**ARTHUR PHILLIP HIGH SCHOOL
AND
PARRAMATTA PUBLIC SCHOOL**

ACCESS REVIEW

SCHEMATIC DESIGN (AC-SD-03)

21st March 2016

1 A03_APHS_GA_LEVEL_6
1:200

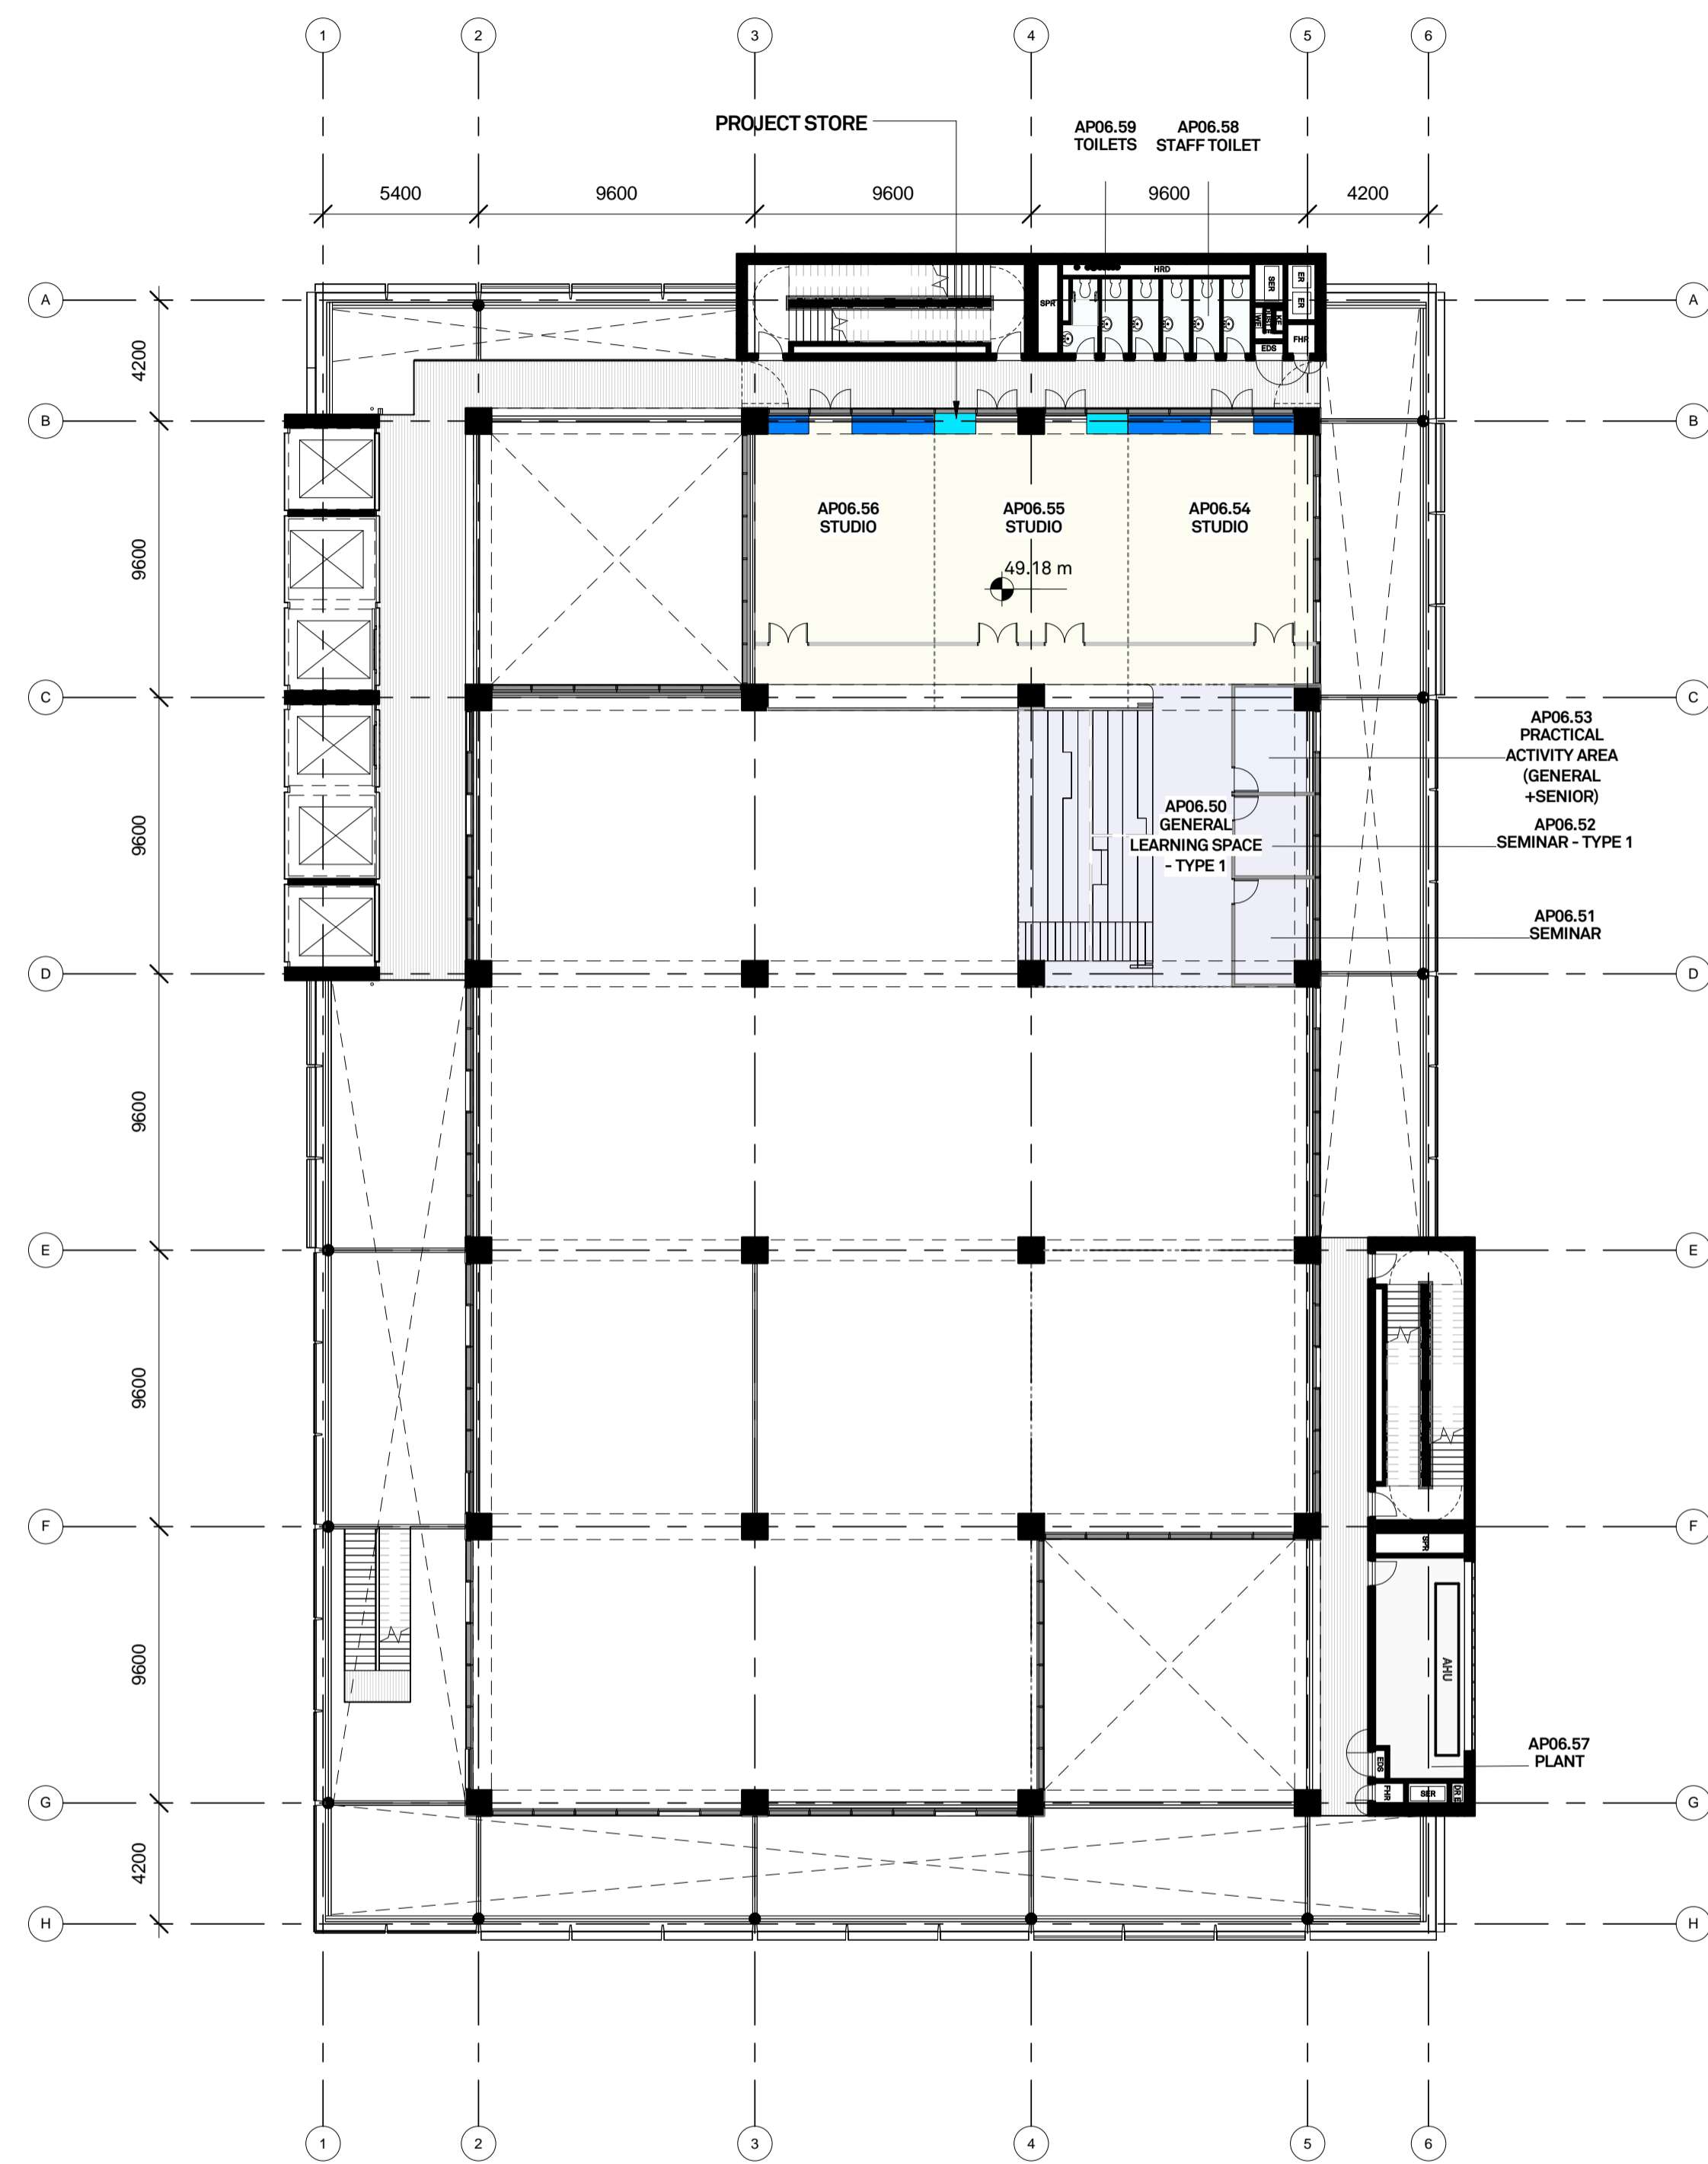
There are communication stairs to access all floors (including the mezzanine levels); they are located on the western elevation (adjacent to the lifts) and the eastern elevation. Any communication stairs will be required to be AS1428.1:2009 compliant. Adjacent to any stair provided best practise is to provide an accessible path of travel, consideration to provide lift access adjacent to the eastern stairs for equitable access. (Best practise - Advisory).

- (i) On the perimeter walkway of the APHS ensure there is a passing space (1800mm x 2000mm) at max., 20M intervals where a direct line of sight is not available, compliant with BCA2015 and AS1428.1; 2009.
- (ii) A minimum path of travel of 1M is to be provided within the security zones, compliant with AS1428.1.
- (iii) Handrails to communication stairs are to be of a continuous height provided both sides of the stair, of a minimum spacing of 1M apart and to have handrail extensions top and bottom of stairs, compliant with AS1428.1:2009.
- (iv) Consideration to provide a lift adjacent to the eastern communication stairs for equitable access. (Best Practise – Advisory)

- (iii) Where fixed tiered seating is proposed provide a wheelchair seating space of min., 800mm x 1250mm, compliant with AS1428.1:2009.
- (iv) Within learning spaces where there are stairs provided to upper seminar rooms/learning spaces (located on a mezzanine level), locate this type of learning space in close proximity to the western lifts for equitable/inclusive access (i.e. to minimise travel distance and identify alternate accessible path of travel).
